## **Sikh Grammar School, Rouse Hill – SSD 9472**

The Government Architect NSW (GANSW) has been asked to provide independent design review and commentary on State Significant Development application SSD 9472. Please find our response below.

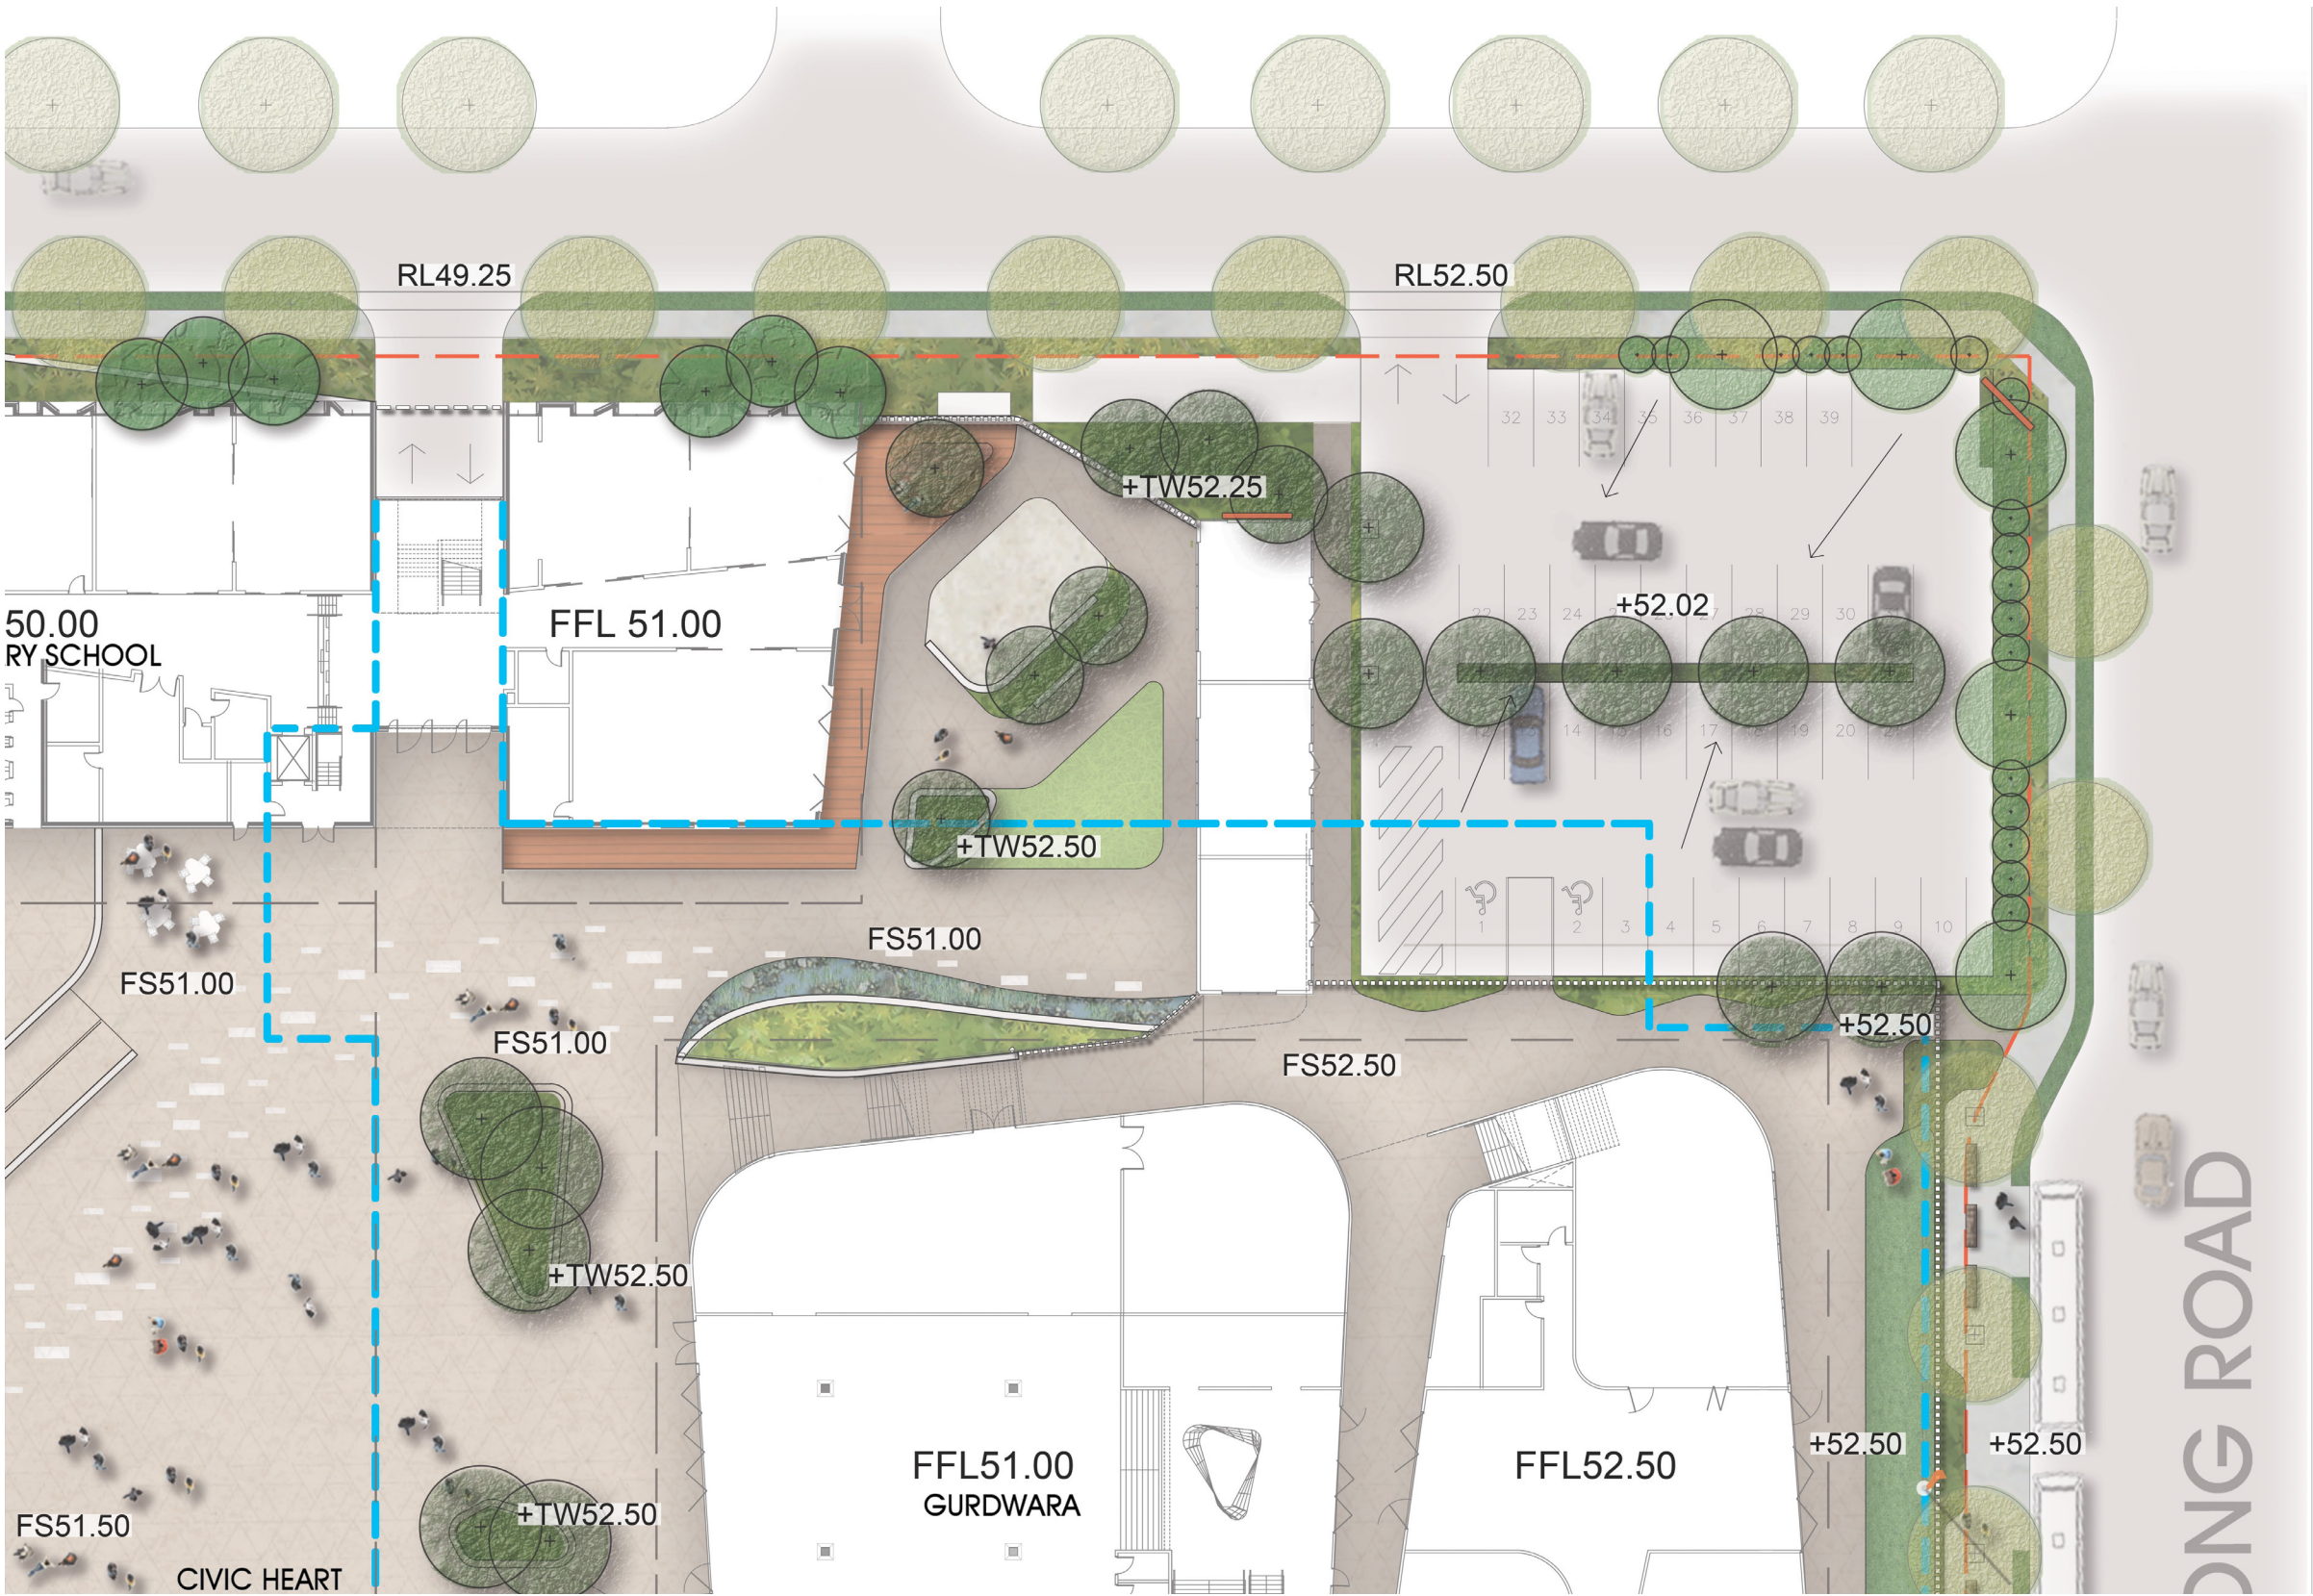
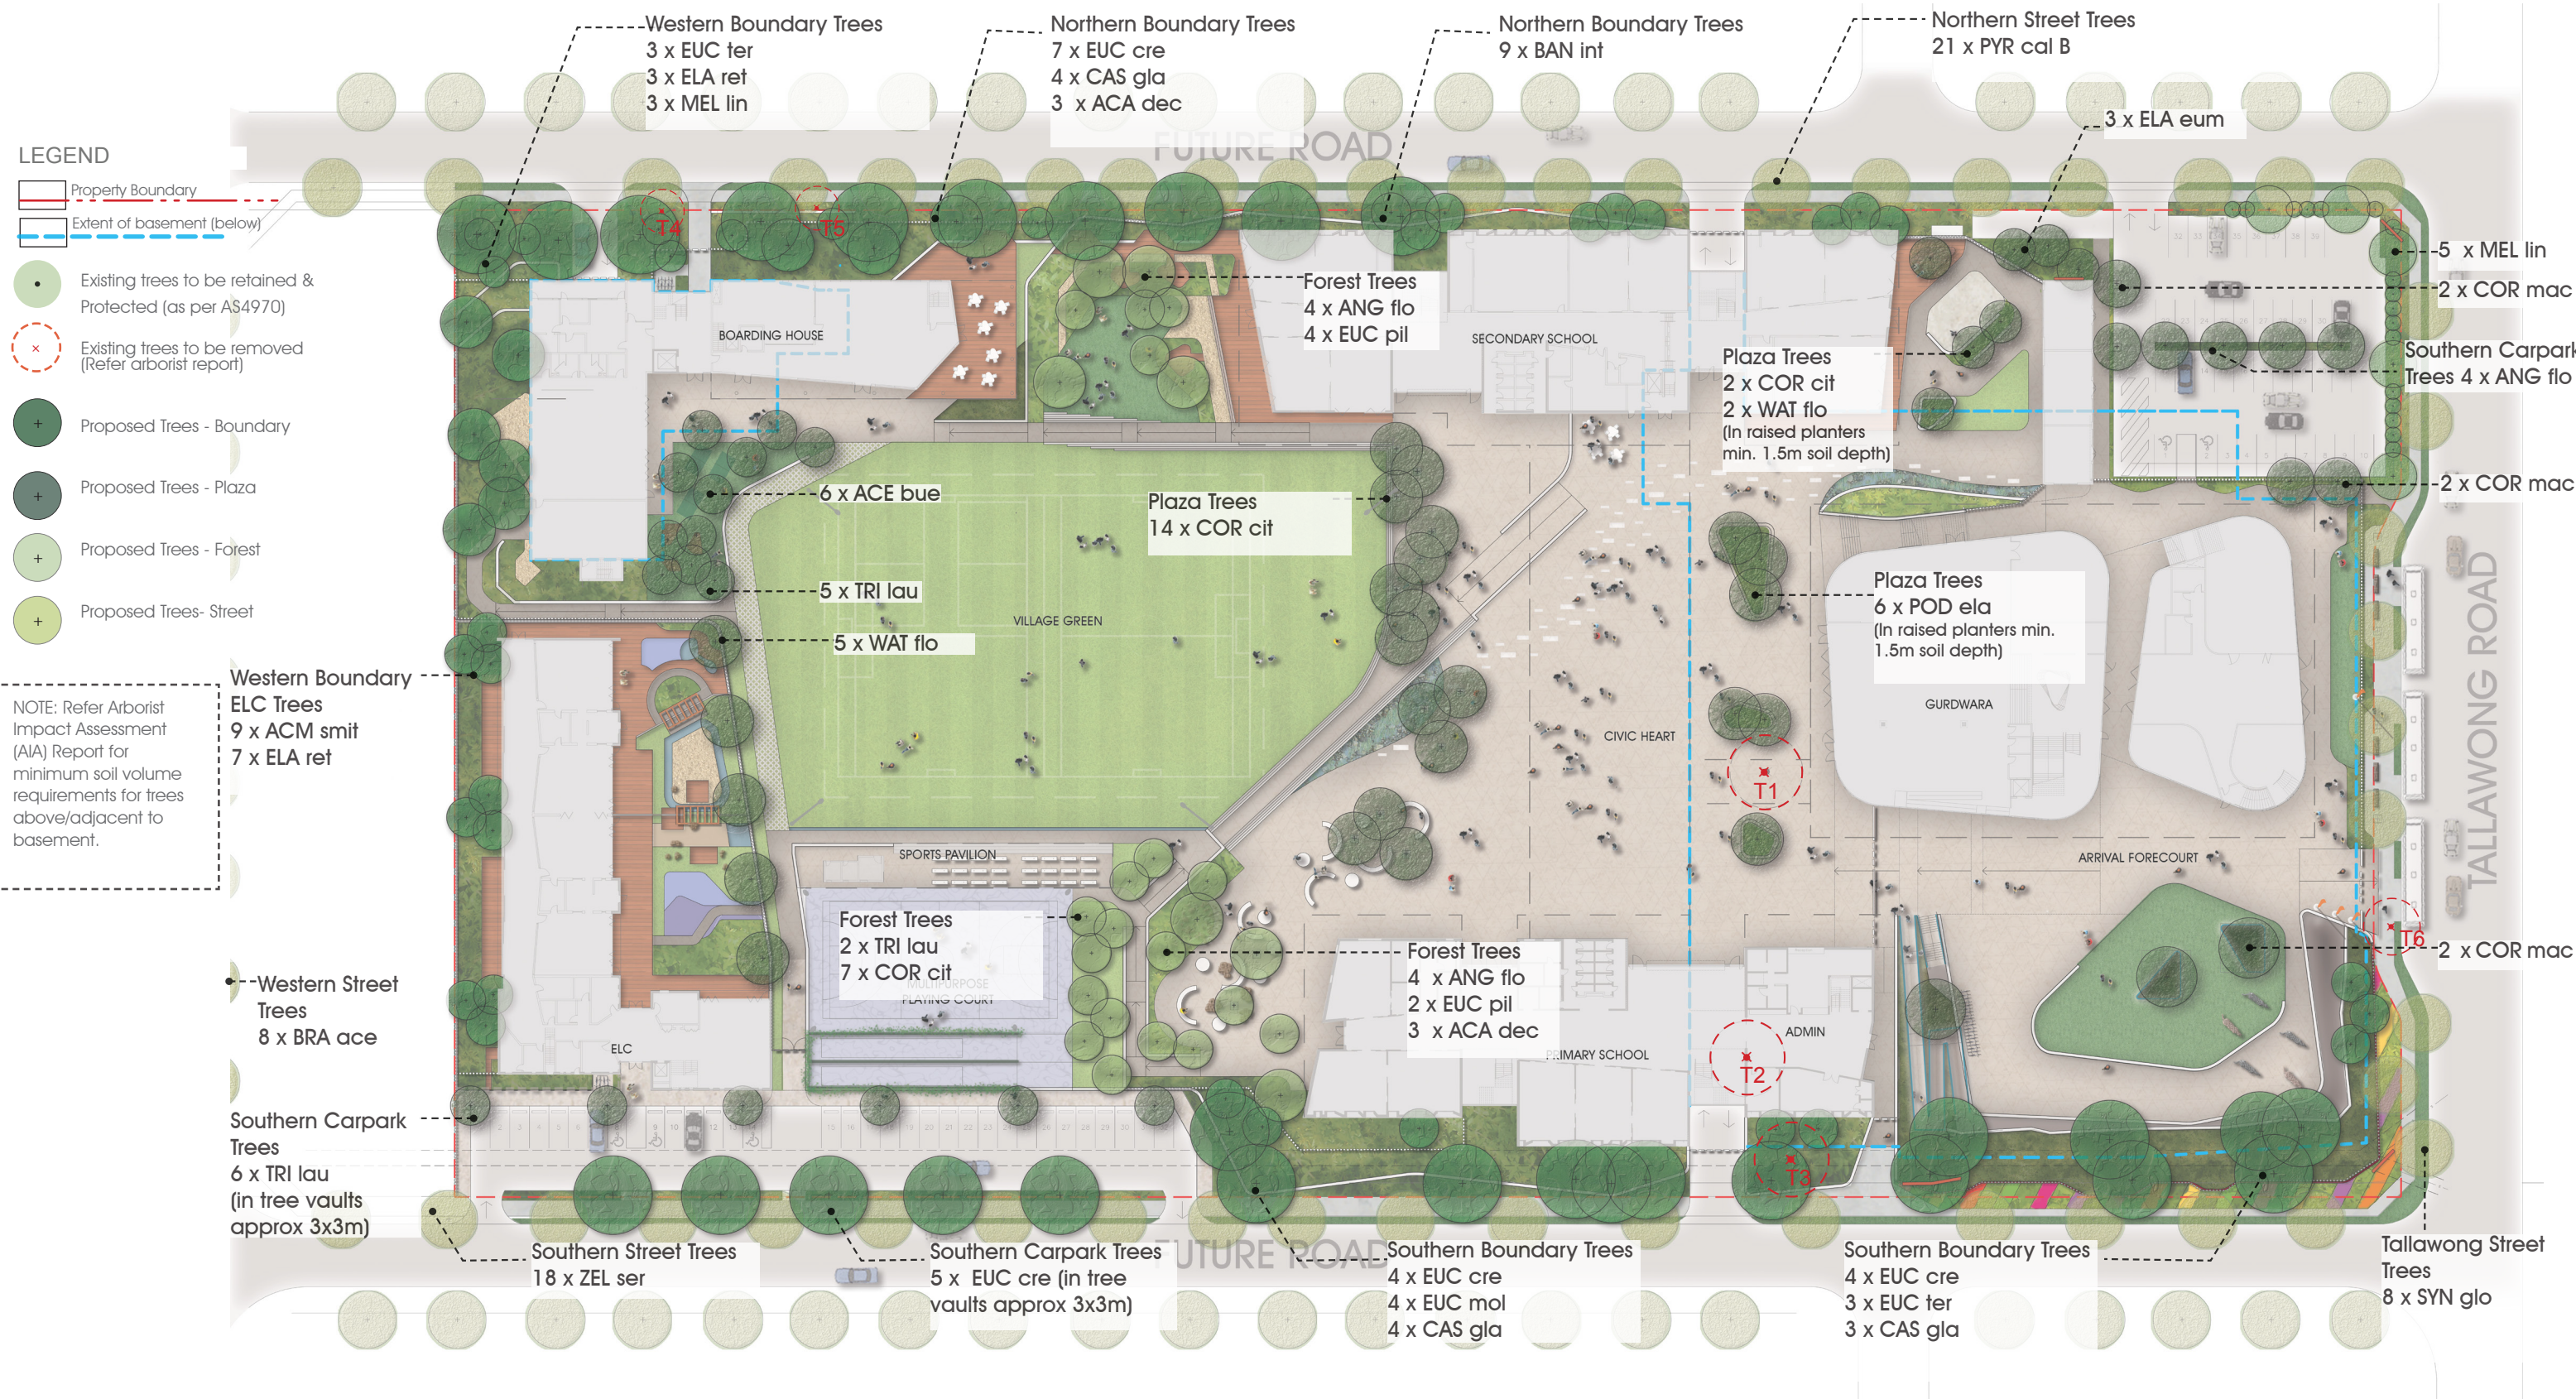
A short review of the layout and staged implementation of the canopy cover raises the concern that the canopy cover will not be achievable (as drawn) due to the variables of integration with future street landscaping under the DCP, project staging and the delivery/construction process generally: This includes:

- Spatial compatibility between future street trees and School perimeter planting.
- Insufficient space between the Secondary School & the north-west boundary for mature planting
- Deep soil ( min1500mm) depth for mature planting at locations with basement carparking under.

GANSW recommend a commitment to the (as proposed) canopy target – allowing for flexibility of location /distribution of trees relative to 1) shading quality/ maximum positive impact & 2) each stage of the project.

It is noted that areas such as the carpark to ELC interface are reliant on the street trees and could potentially cater for additional planting. This demonstrates the risk of reliance on factors yet to be determined (e.g finalise street tree layouts aligned with the DCP)
